Prior Notification for a Permitted Development (Householder)

Development: Notification under extended permitted development rights for a single storey rear extension measuring 5.5m from beyond the rear wall of the original dwelling house, with a maximum height of 2.91m and an eaves height of 2.46m.

Location: 37 Torton Hill Road Arundel BN18 9HF

Prior Notification Works	
Client: Nick Carter & Natasha Peskin	
Project: 37 Torton Hill Road, Arundel	
Drawing: Proposed Elevations Sheet 1

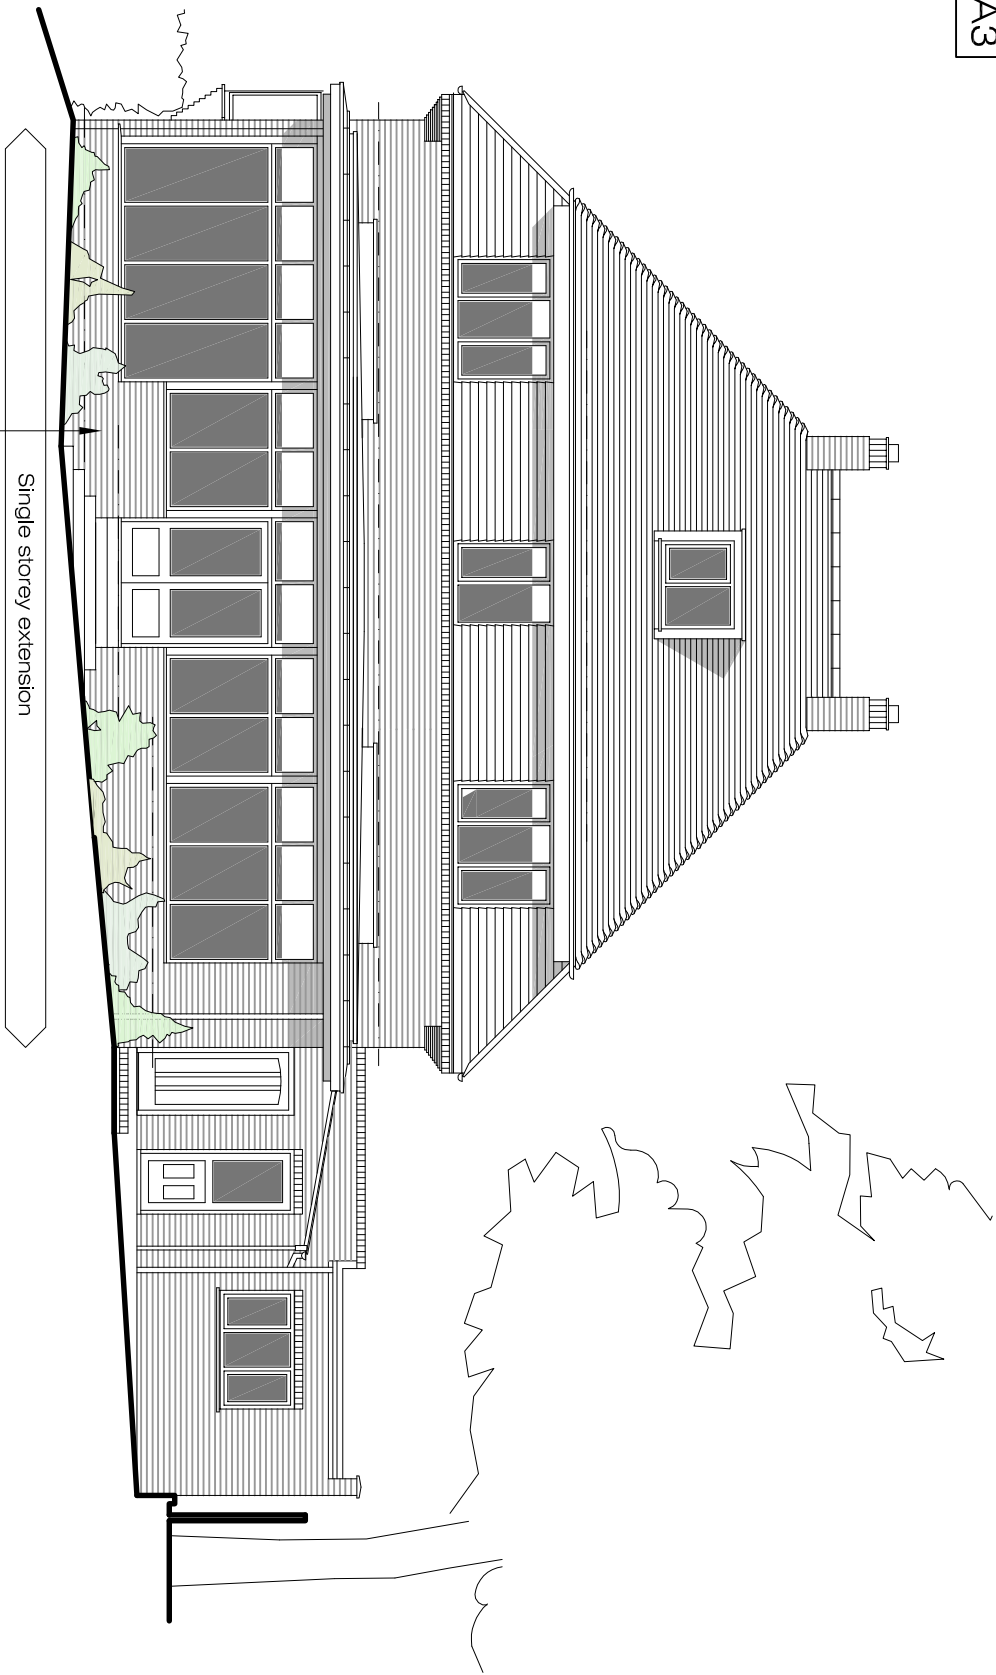
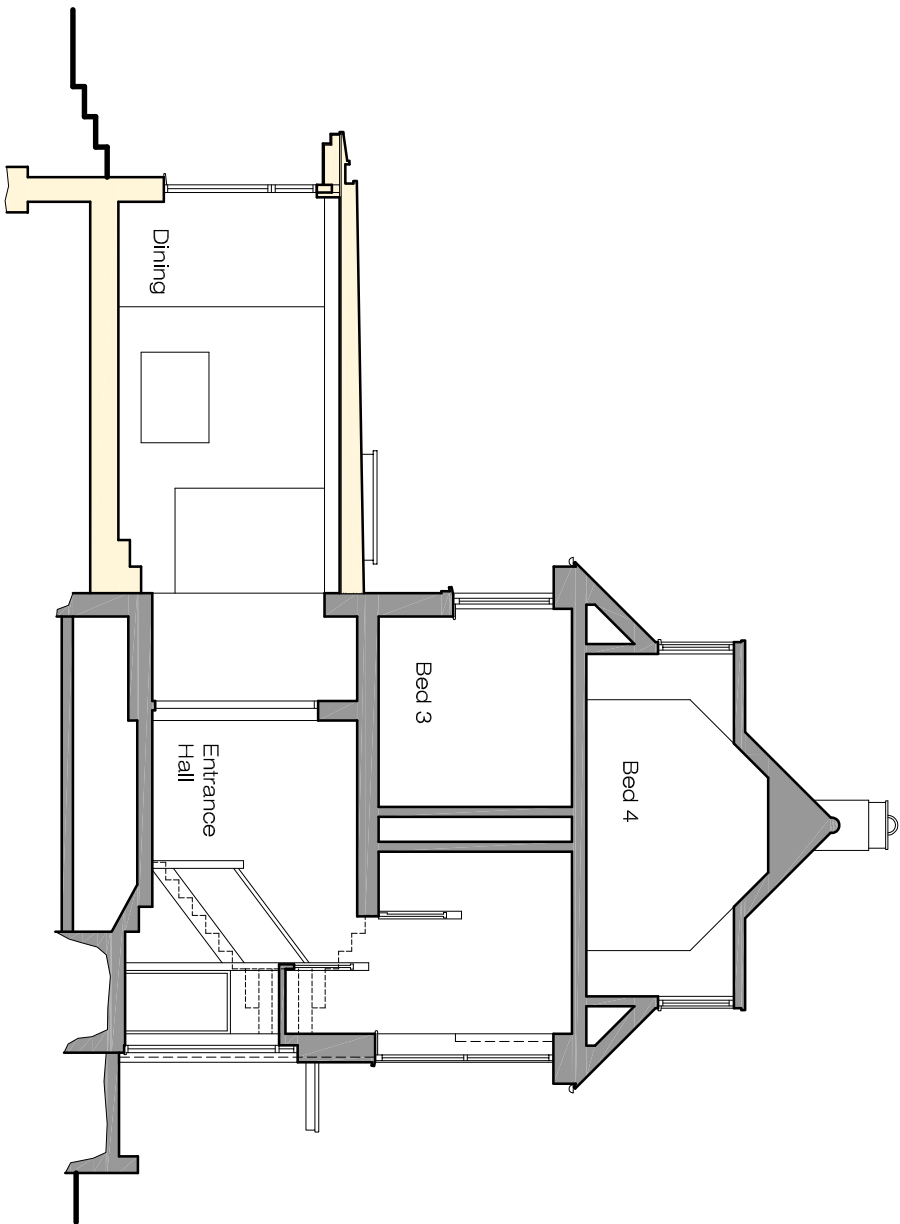
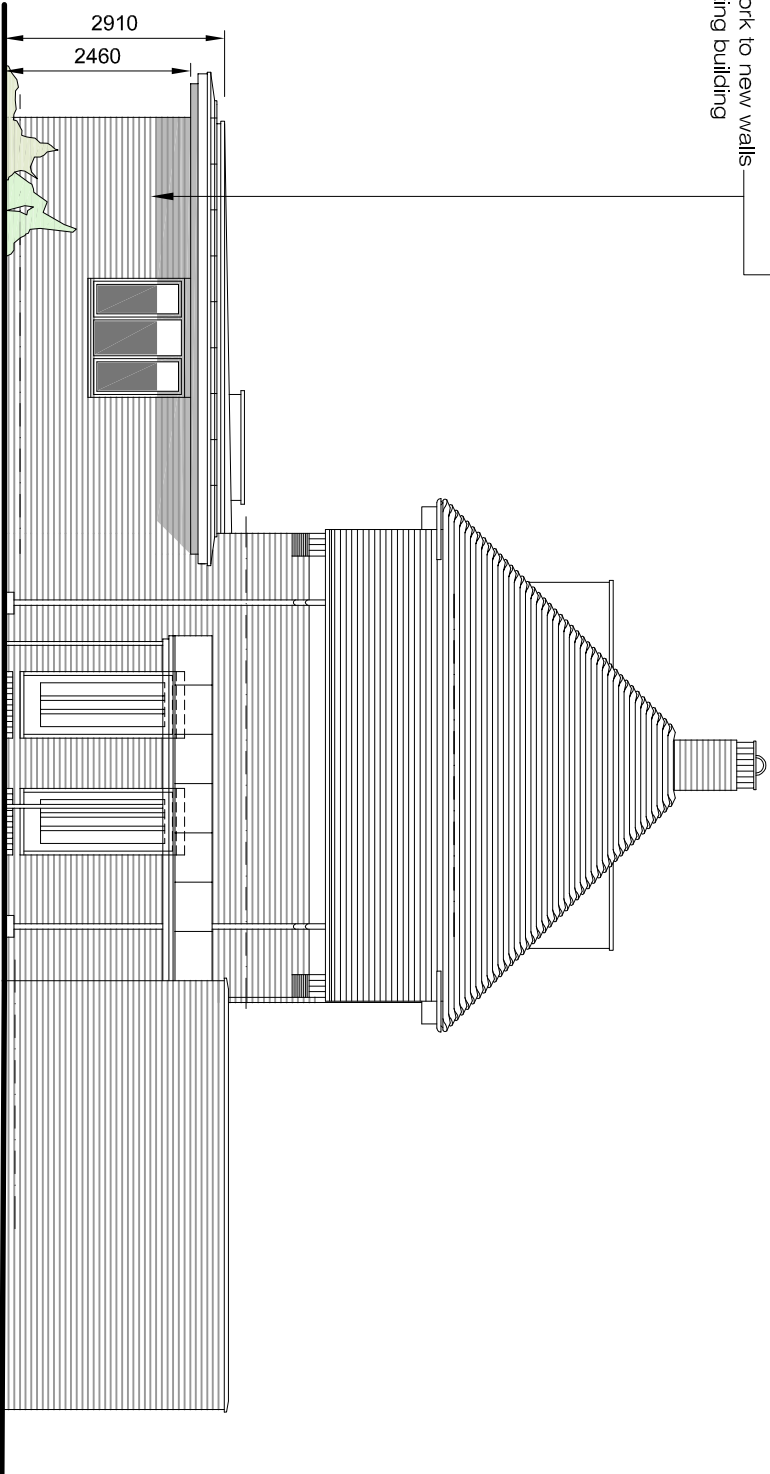
Please amend the maximum height of the proposed development on the application form to include the roof lights and amend the eaves height to match the elevations (2.46m).
